CITY OF ALBUQUERQUE

March 5, 2020

**Re: Chick-fil-A, Coors Blvd.
4001 Coors Blvd NW, 87120
30-Day Temporary Certificate of Occupancy
Transportation Development Final Inspection**
Engineer's/Architect's Stamp dated 1-28-19 (G11D069C)
Certification dated 2-28-20

Sheet
C2.0

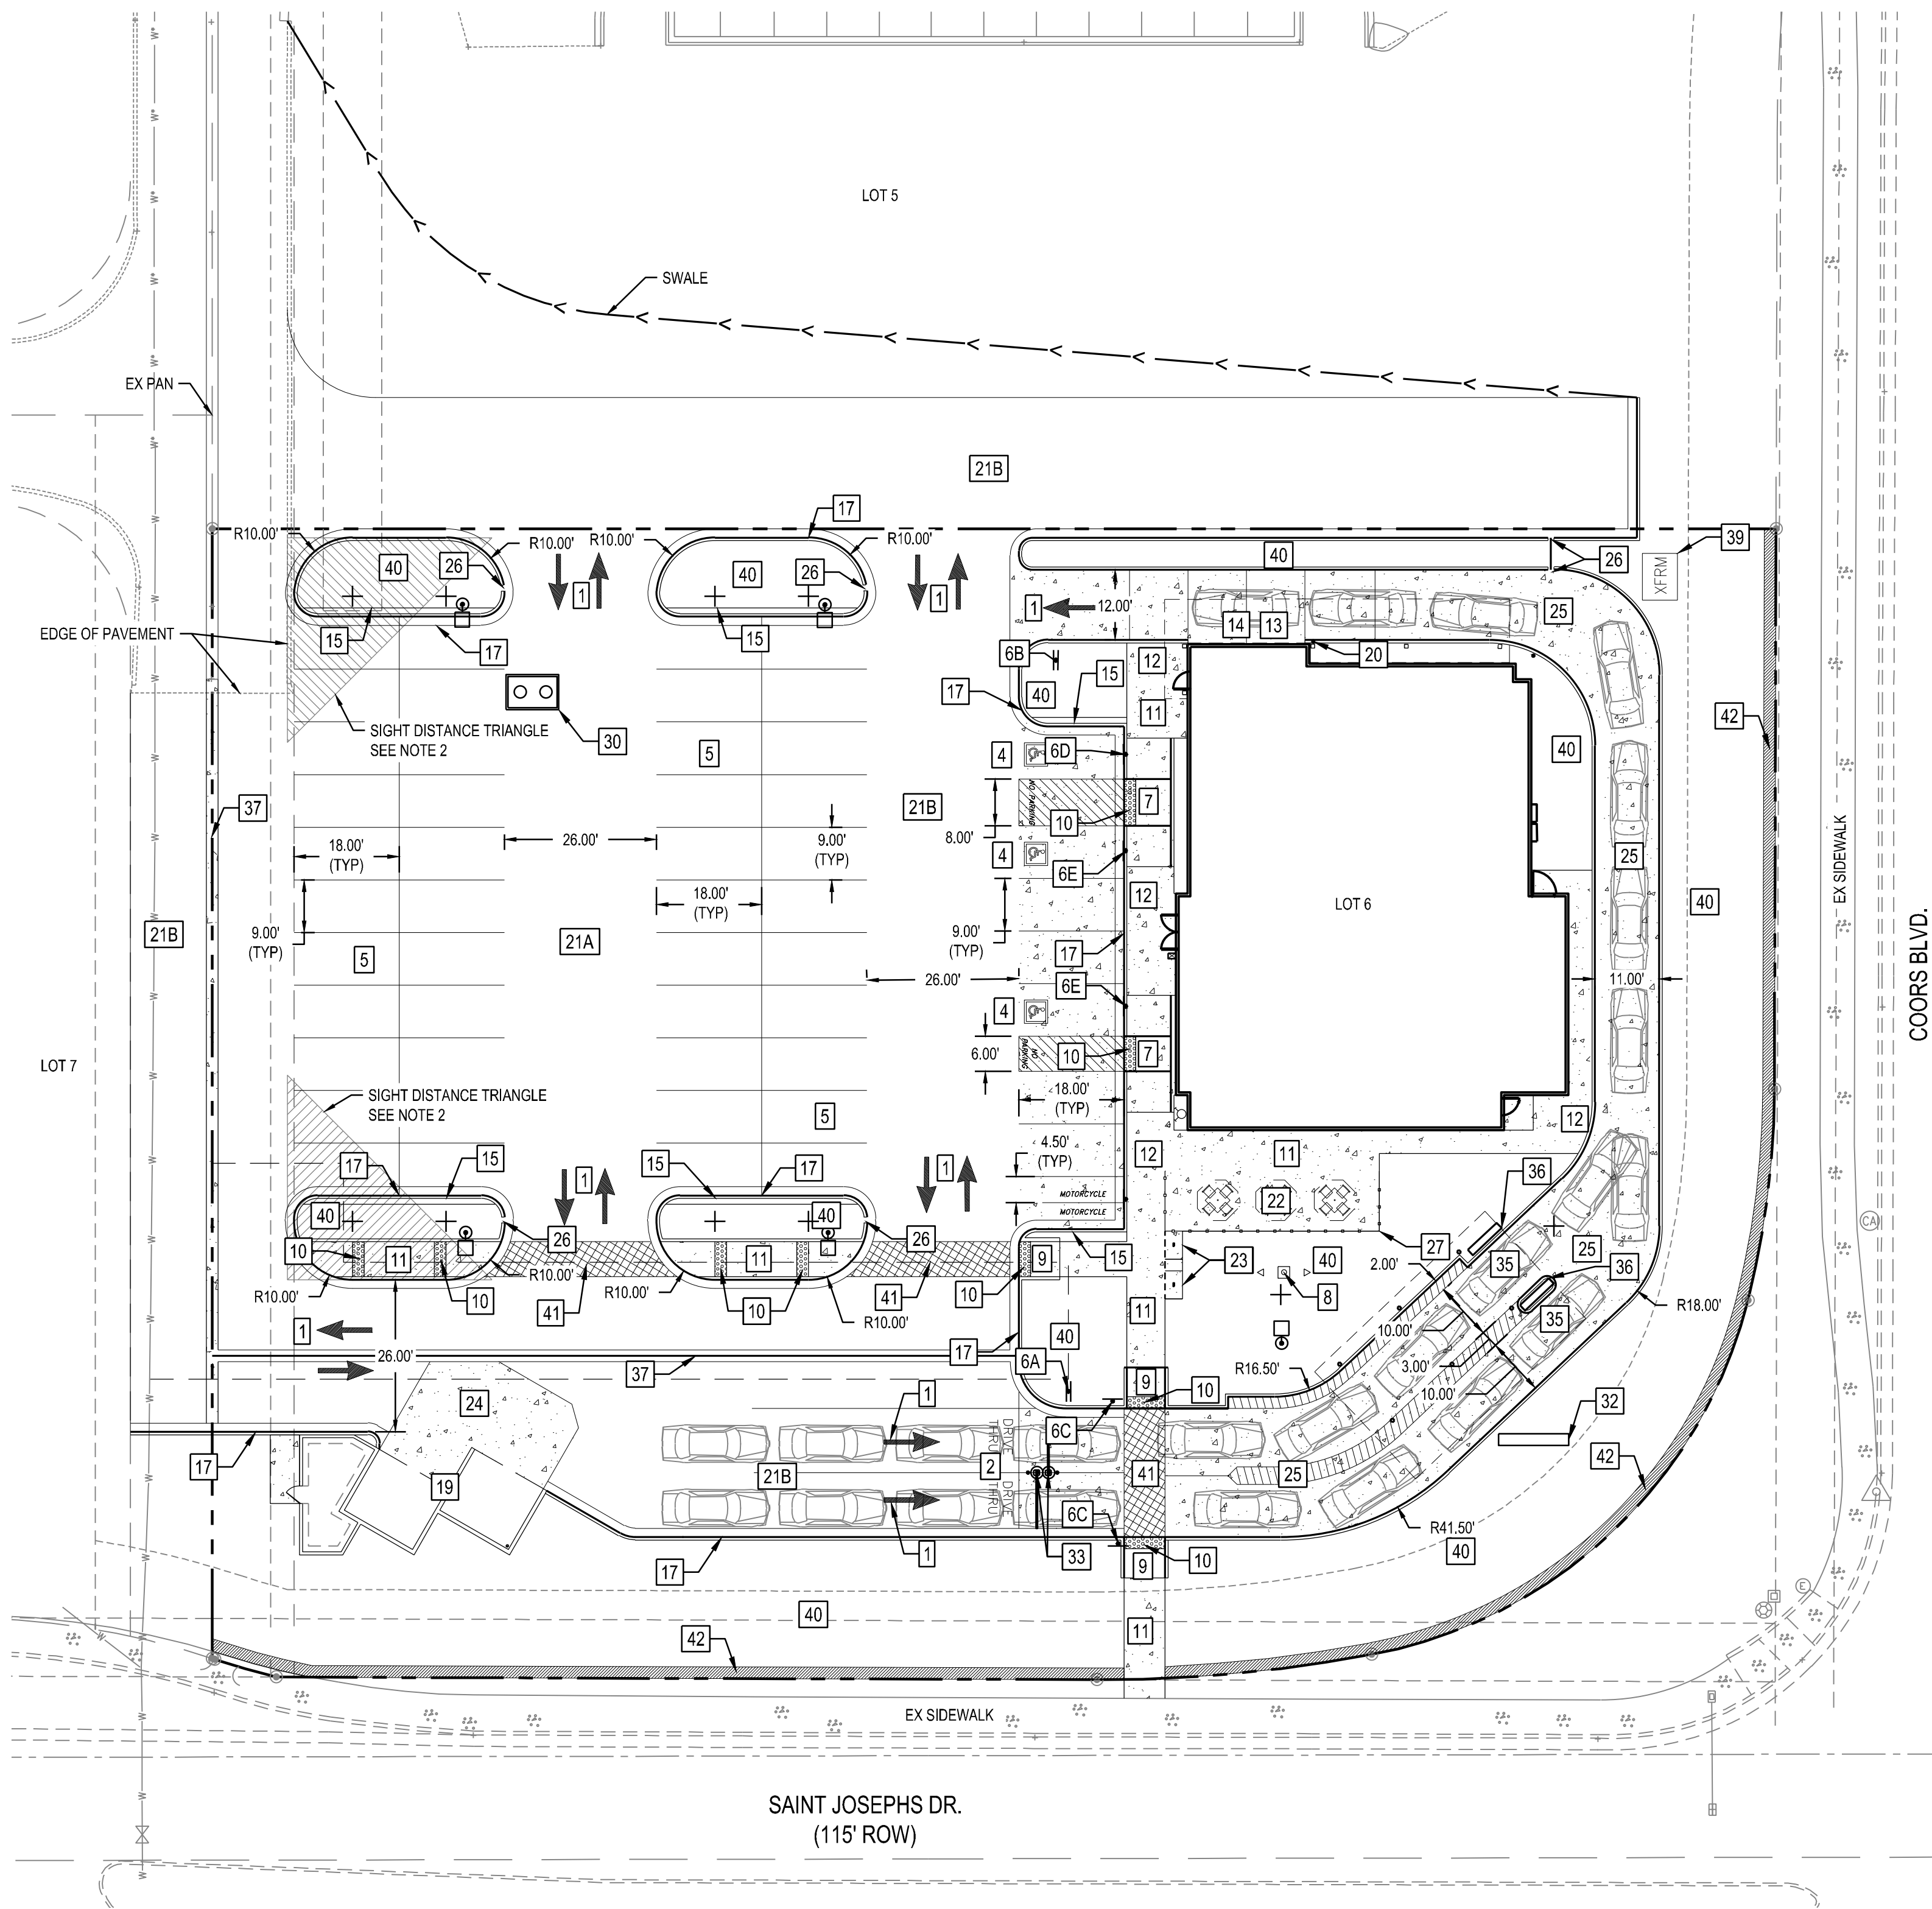
1. Please update ADA parking Stall Signs. The ADA accessible parking sign must have the required language per 66-7-352.4C NMSA 1978 **"Violators Are Subject to a Fine and/or Towing."** Please call out detail and location of signs.
2. Please add missing Motorcycle Signs.
3. Please remove trash container, porta potty, construction equipment and material.
